RE: Revised BDAR Spatial Data –Tweed Sand Plant Expansion, Cudgen Tweed LGA (SSD-10398)

Attachment 1: Detailed BCD Comments – Revised Spatial Data Tweed Sand Plant Expansion, Cudgen

End Use Plan

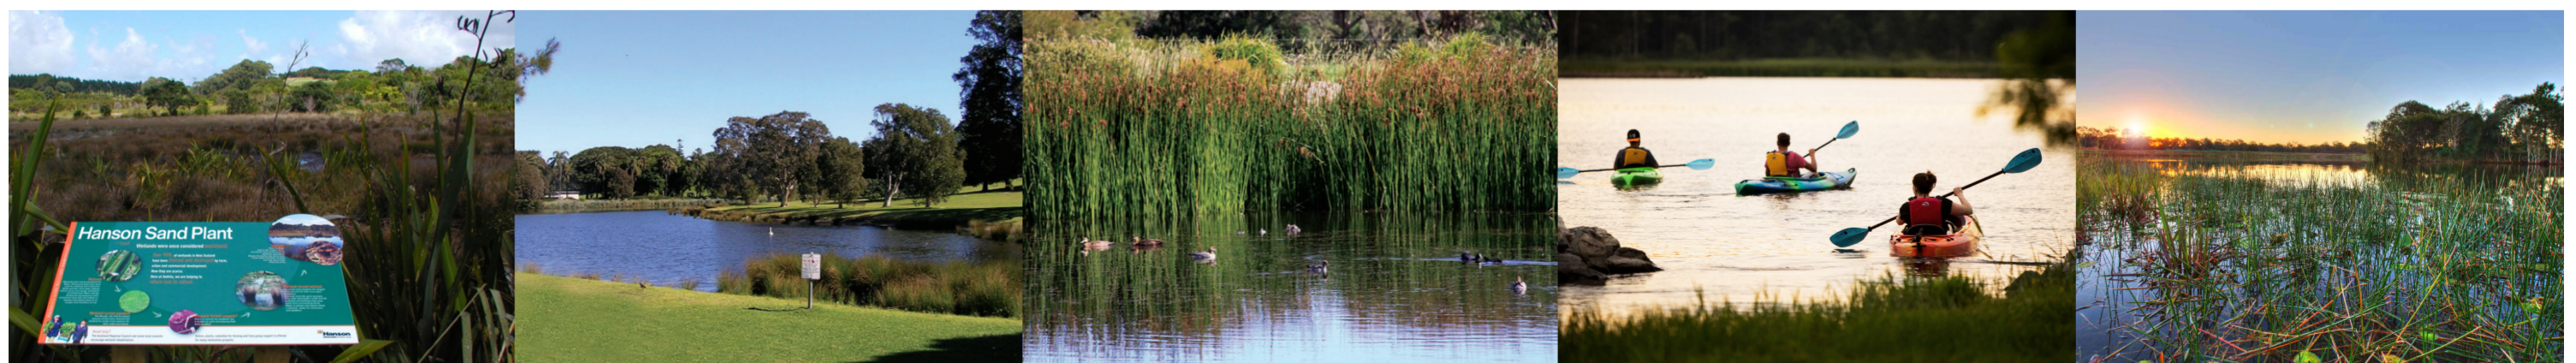
We also note discrepancies with the extent of rehabilitation areas as mapped in the End Use Plan in the *Concept Rehabilitation and Landscape Management Plan* (April 2022 JWA) compared to the mapping of retained Approved Riparian PCT 1235 and Approved Wetland PCT 1290 communities as shown in Figure 2 below.

Figure 2. Approved Riparian PCT 1235 (green polygon outlined in red) and Approved Wetland PCT 1290 (blue polygon outlined in red) mapping compared to rehabilitation areas as described in the End Use Plan.

The BDAR calculations should be reviewed and rectified once all our previous recommendations have been fully addressed as the implementation of our recommendations will affect the final extraction footprint.
